Current Zoning: B-1SCD (business shopping center, conditional)
Proposed Zoning: UR-2 (CD) (urban residential, conditional)

Approximately 2.56 acres located in the northeastern corner of the intersection of West Boulevard & Holabird Lane.

The petition proposes to allow the development of up to 29 single family attached residential units on a vacant, wooded property. The site is located in the West Boulevard corridor near the Renaissance community.

**HOLABIRD LANE & WEST BOULEVARD  
CHARLOTTE, NC  
REZONING PLAN**

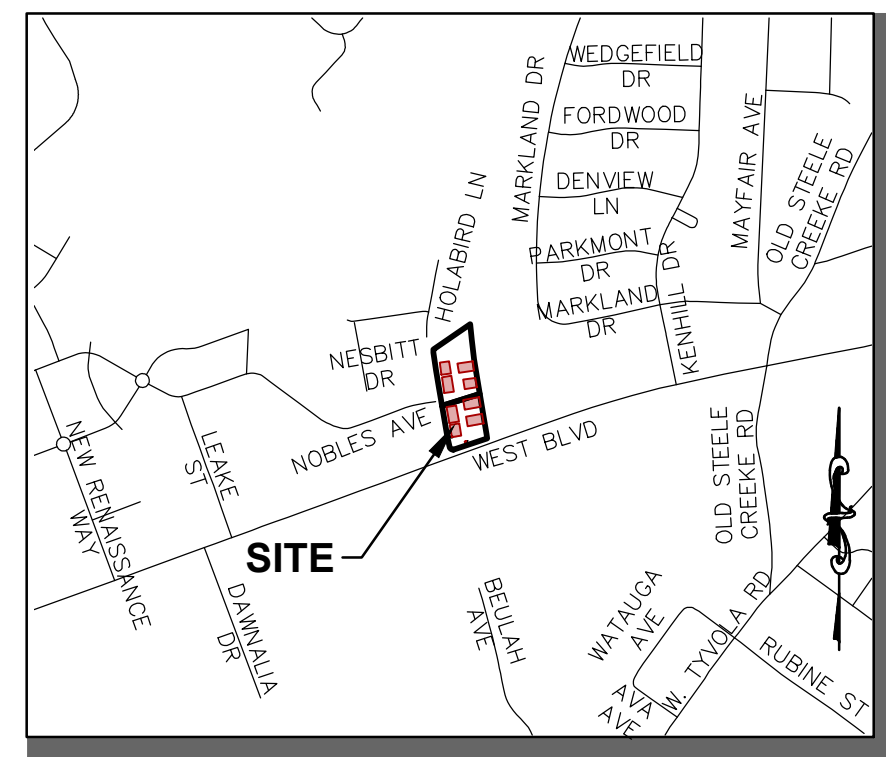
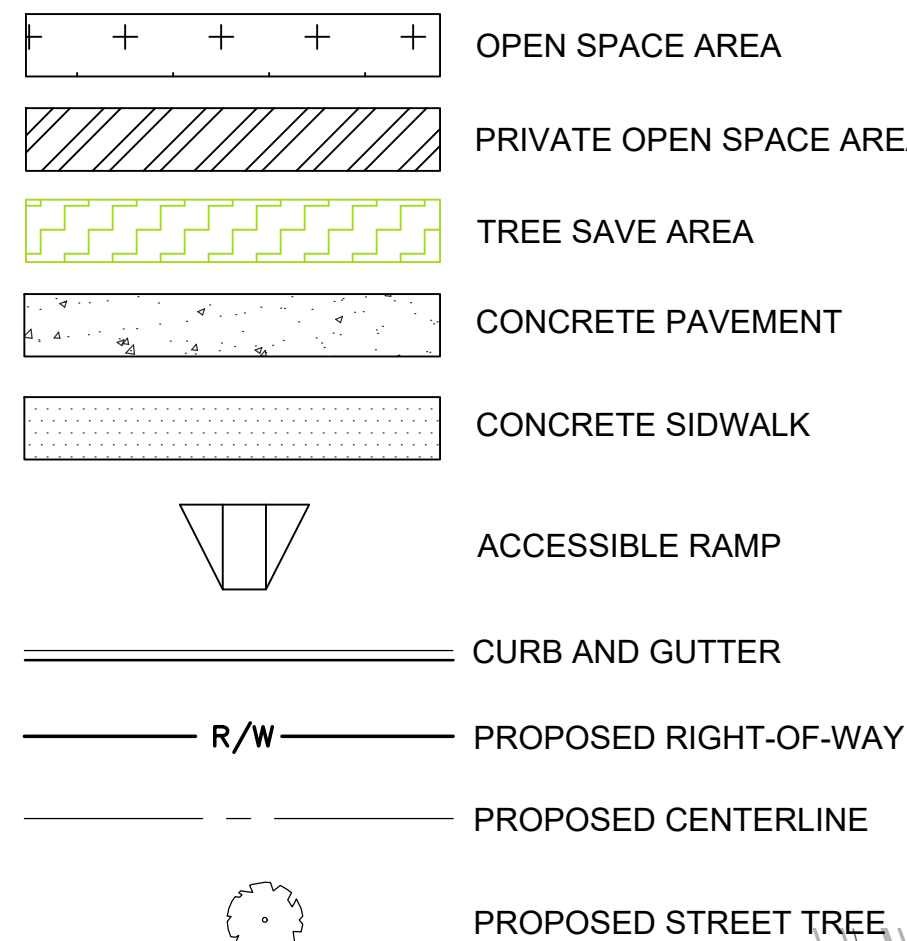
1. Revise the site plan and conditional notes by committing to extending the 8-foot planting strip and 6-foot sidewalk, along Holabird Lane, to the existing sidewalk at the cul-de-sac of Holabird Lane. This sidewalk will provide a pedestrian connection from West Boulevard to the Southwest Recreation Center where a gap currently exists and would assist CDOT in finishing an important pedestrian connection.
-
